DRB Project No: PR-2023-007911 Date: 03/22/2023 Agenda Item: #6 Zone Atlas Page: J-13

Legal Description: [35' PORTIONS OF LOTS 11-14 AND WEST 6" OF LOT 15, BLOCK 28, PEREA ADDITION]

Location: [506 14th ST NW between LOMAS BLVD NW and ORCHARD AVE NW]

Application For: SD-2023-00058-PRELIMINARY/FINAL PLAT (DHO)

**Plat for
Lot 11-A, Block 28
Perea Addition
Being Comprised of
Portions of Lots 11, 12, 13, 14
and 15, Block 28
Perea Addition
City of Albuquerque
Bernalillo County, New Mexico
February 2023**

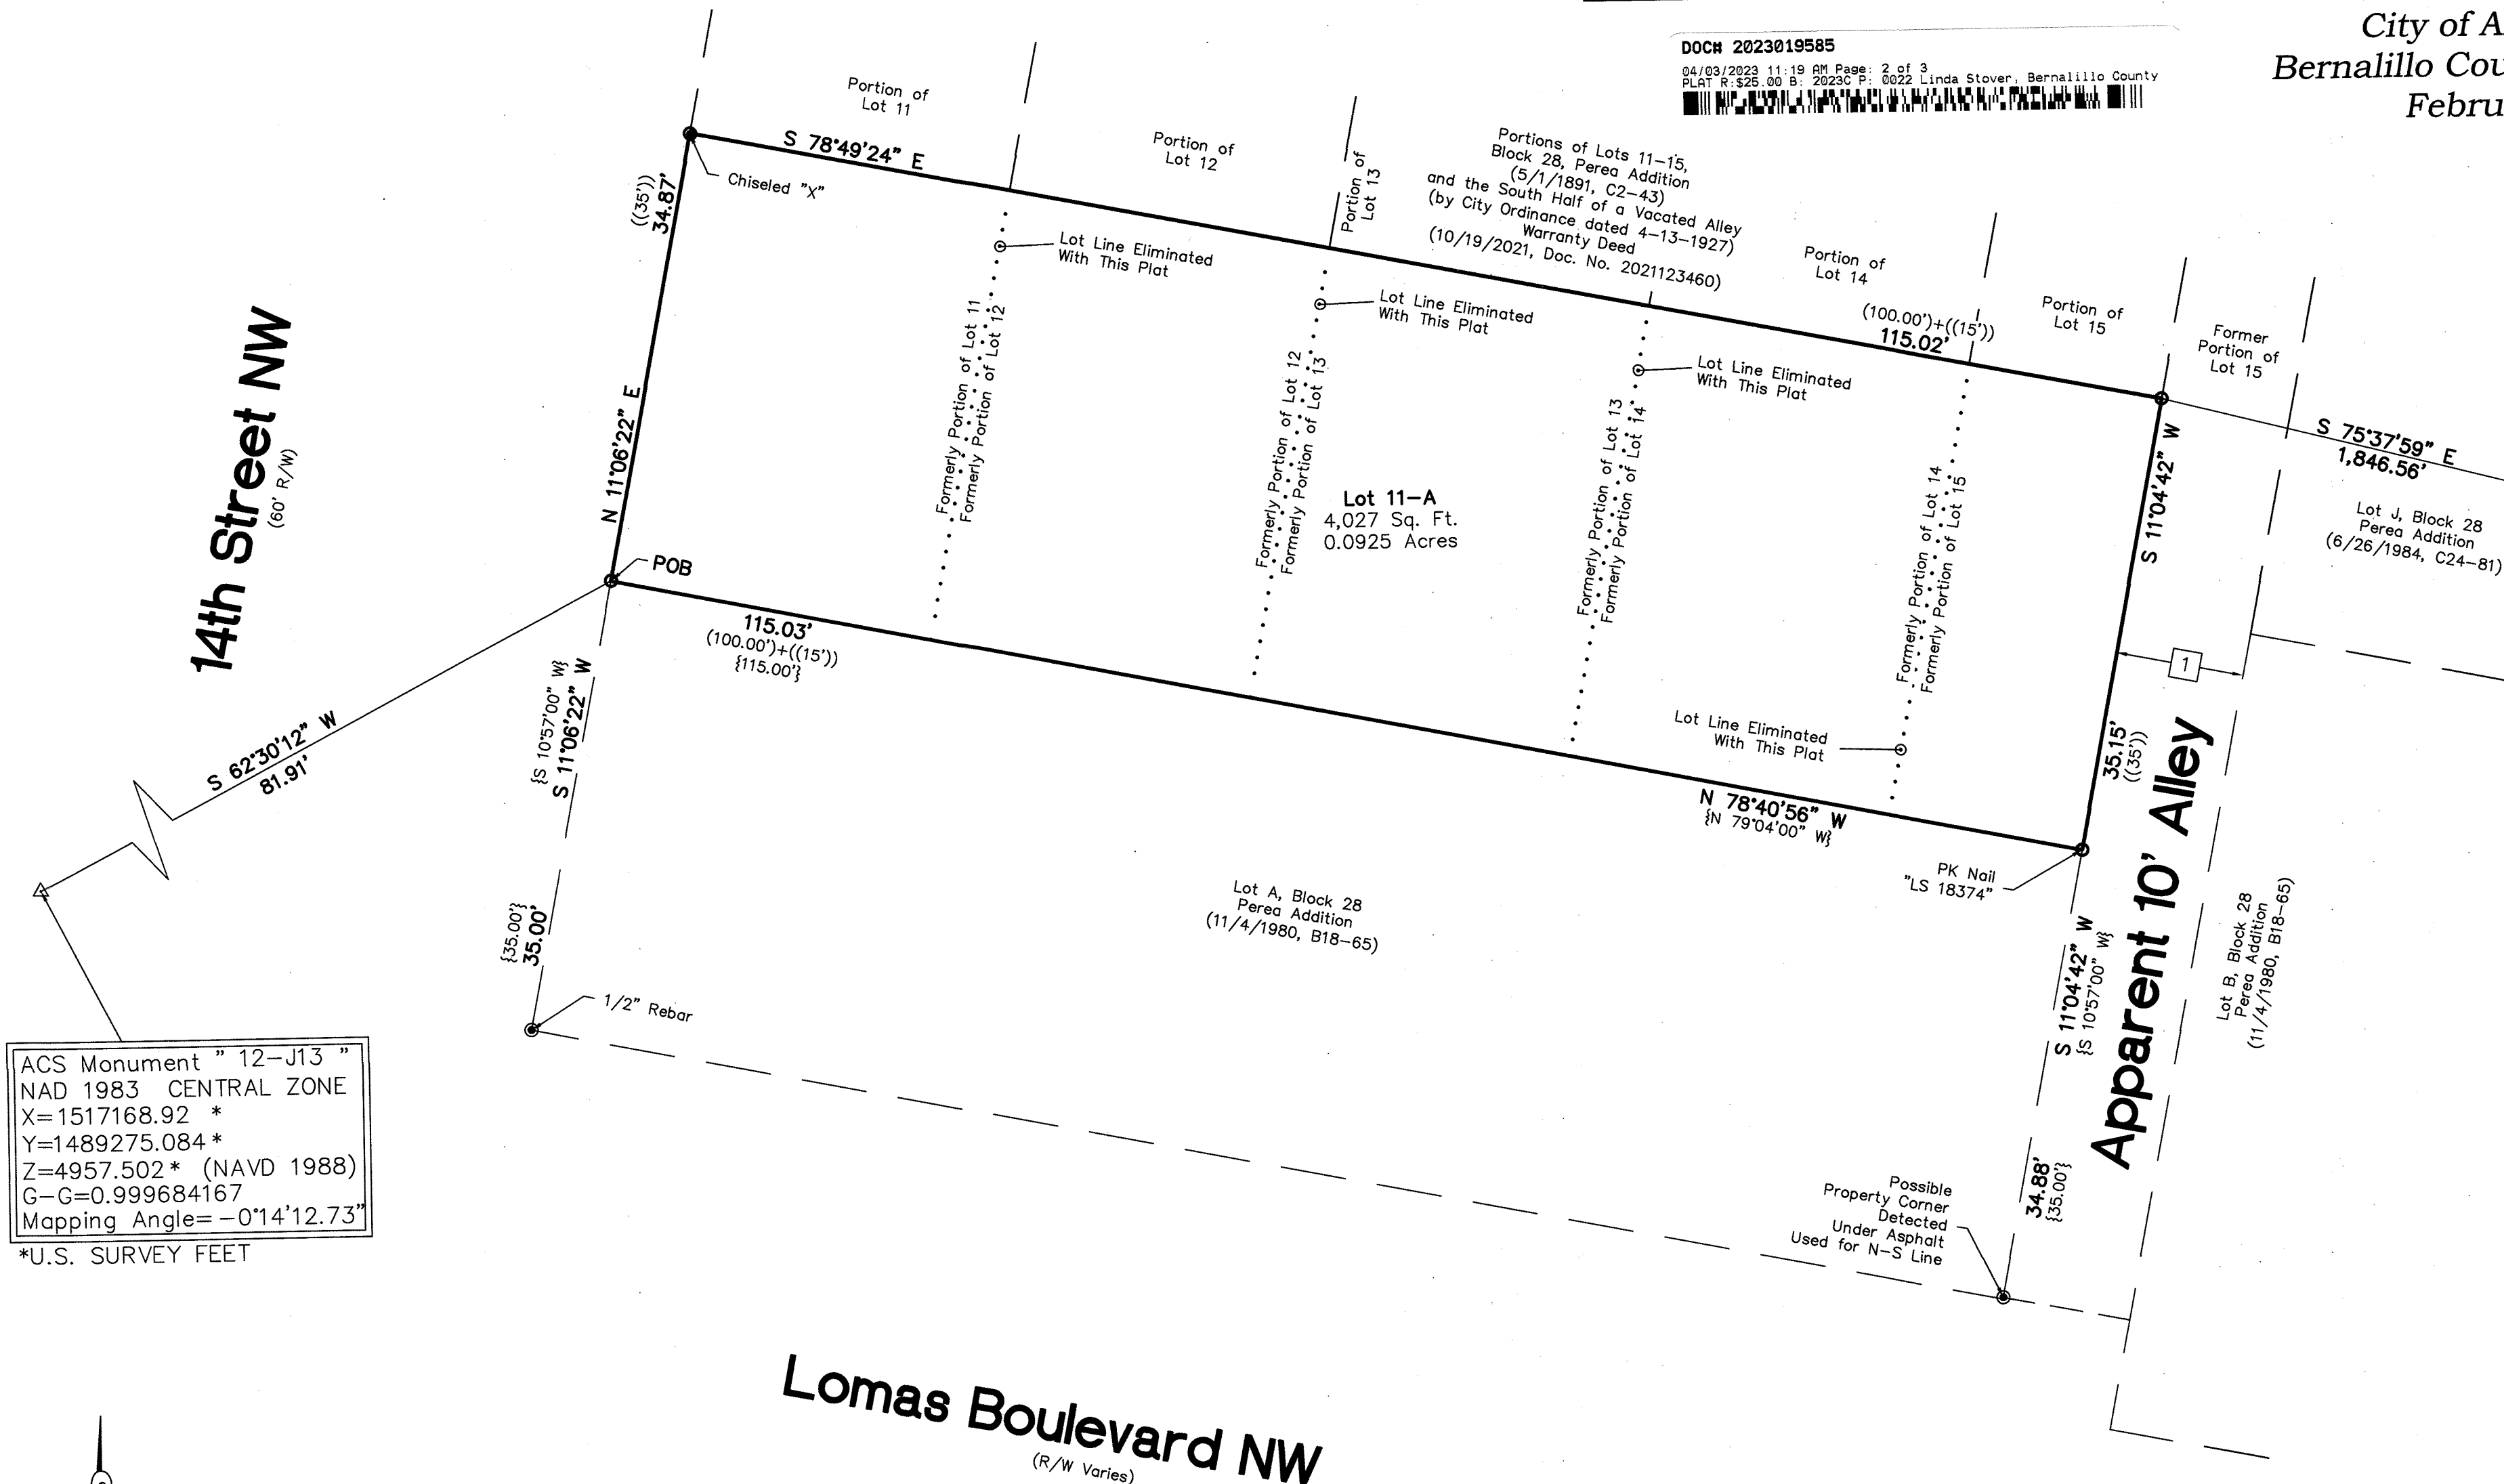
1. No objection to the consolidation.
2. The alley on the east side of the property is constrained with power poles on the side of the applicant's property and walls on the opposite side. Transportation has no objection to allowing this to remain as is.

- Subdivision of Land per IDO section 5-4.
Including but not limited to 5-4-C, 5-4(K) Dedication of Land for Public Purposes, and 5-4(P) Additional Design Criteria and Construction Standards.
Please confirm that you are creating an east-west lot line per the County parcel with this plat. This line does not exist for the City parcels (parcel lines running north/south).

- Please clarify compliance of section 7 of the DPM, Table 7.2.29, regarding sidewalk width and landscape buffer.
14th Street is a local road with desired sidewalk width of 5 feet and a 4-6 foot landscape buffer. Please provide widths of existing sidewalk/landscape buffer. **If less than these amounts, provide a letter of justification to maintain existing widths.**
The Parcel is in a Major Transit Corridor (Lomas) while not having frontage on Lomas. This would generally require a 6-10 foot sidewalks and 6-8 foot landscaping buffer. However, this application is meaningfully decreasing the degree of nonconformity in creating one lot for the existing building. Therefore, this standard can be waived.

- The request for a DPM waiver to retain a 10-foot alley (in lieu of standard 20-foot alley) that has been in use since the 1950s has submitted justification.
